Demolition & erection of 1 No. dwelling with integral garage.

72 Ancton Way Elmer Middleton on Sea

*Re: Planning Application M/94/17/PL
72 Ancton Way Development*

PROPOSED FIRST
FLOOR PLAN @ 1:100

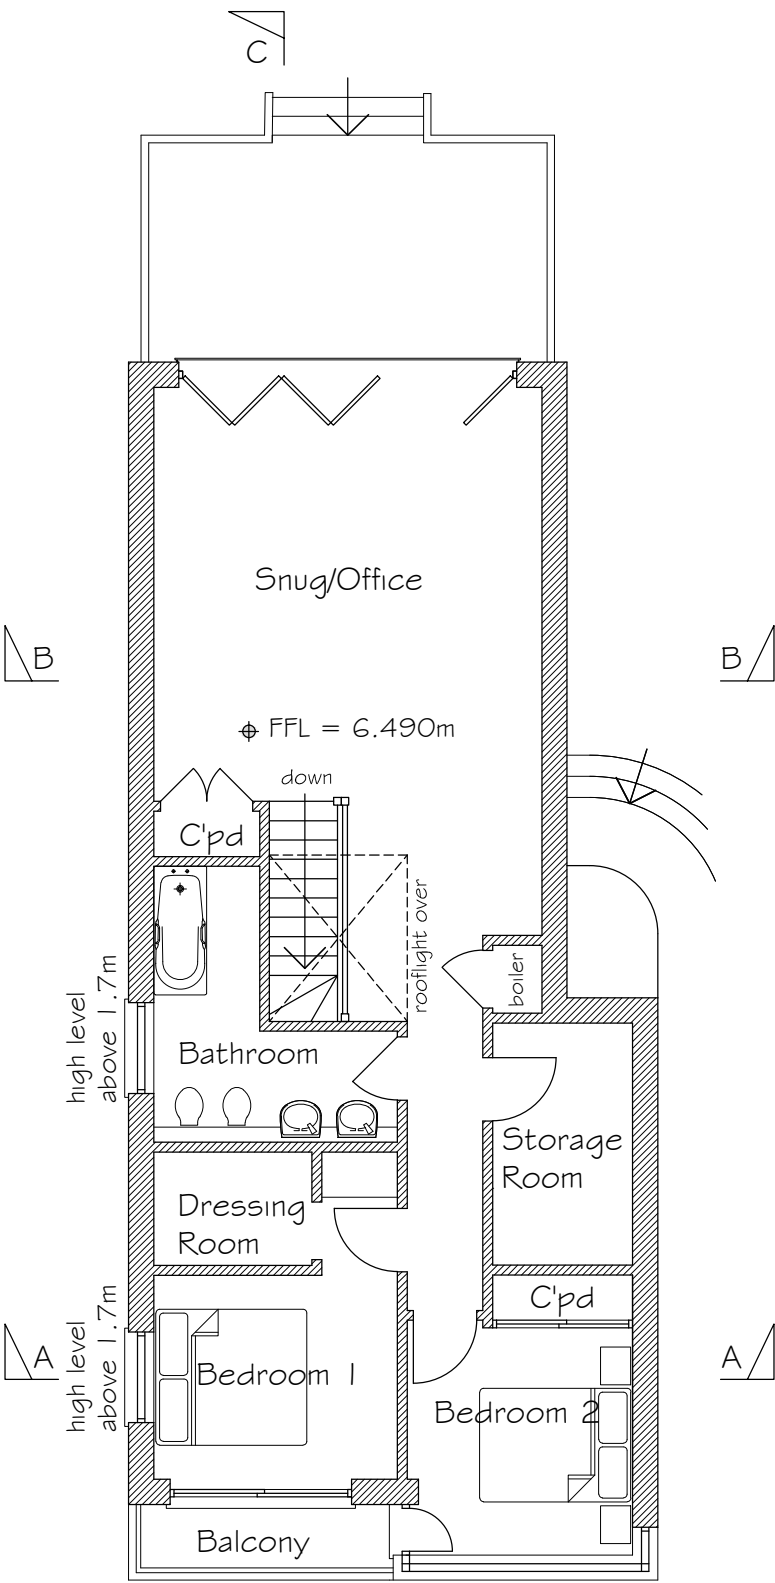
*2/ Full length/height windows/patio doors to the rear of the first floor will provide unhindered views directly into both gardens on either side.
On standard construction buildings usually the first floor is used for bedrooms. The proposal intends this as a day room for general daytime usage, this would be at the same time as most people enjoy use of their garden for private leisure. The proposed windows will therefore have elevated, clear visual access to adjoining gardens from any persons position, seated or otherwise within the room. This will remove all privacy to the greater part of both the adjoining properties rear gardens, giving a watchtower feel!*

PROPOSED NORTH ELEVATION @ 1:100

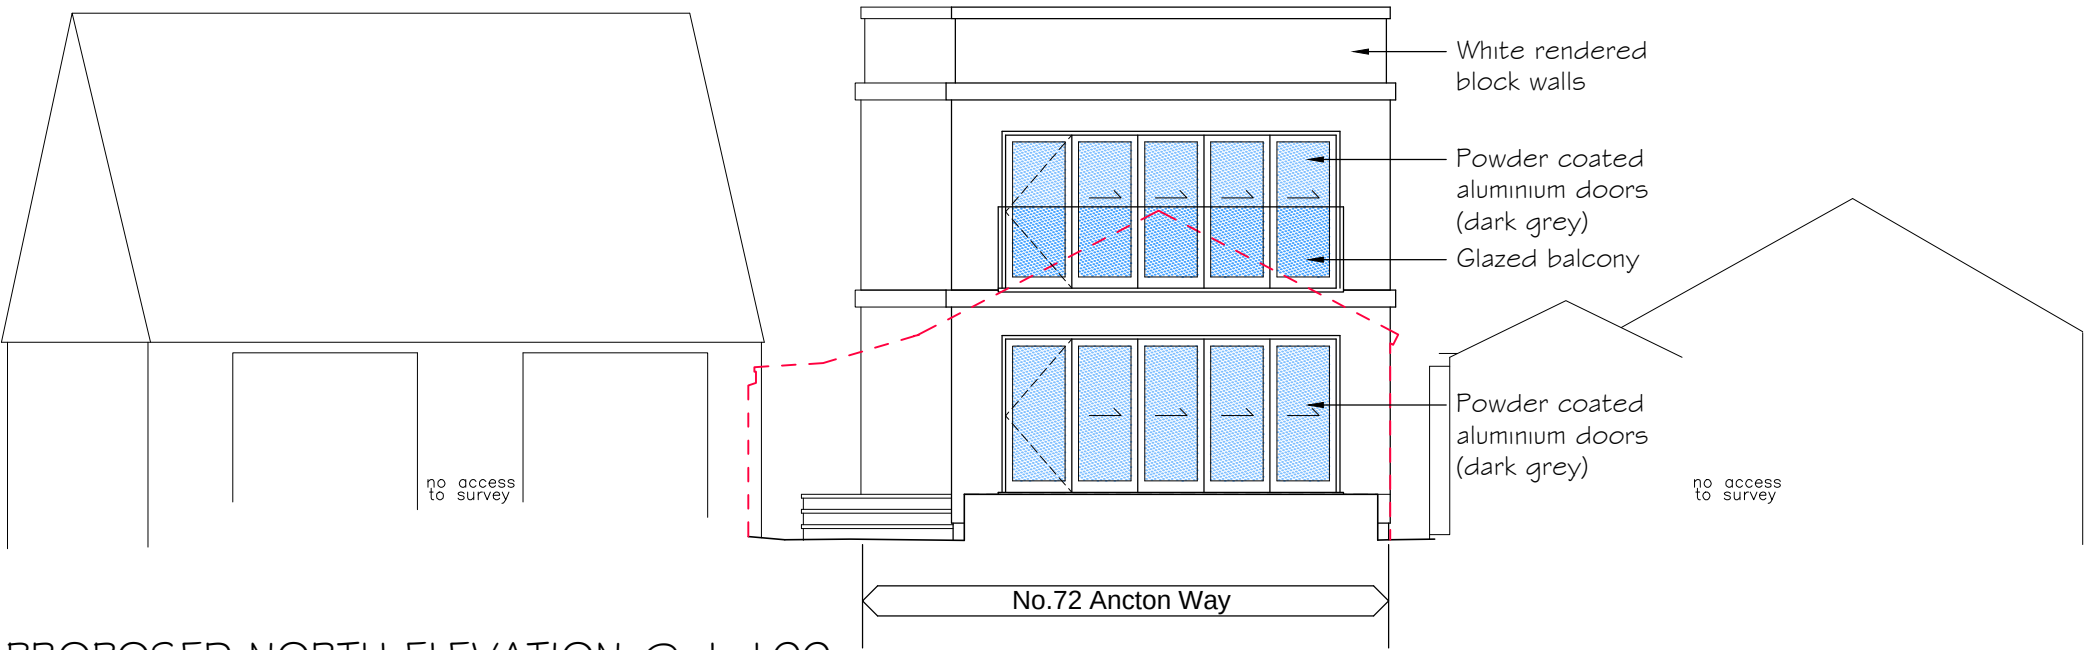
3/ The 'cube' nature of the construction to existing roof height (no. 74) at the rear of the proposed design will greatly reduce sunlight over both adjoining properties rear patio areas (ironically the ONLY private areas of adjoining gardens not overlooked by the proposed full length first floor windows!).
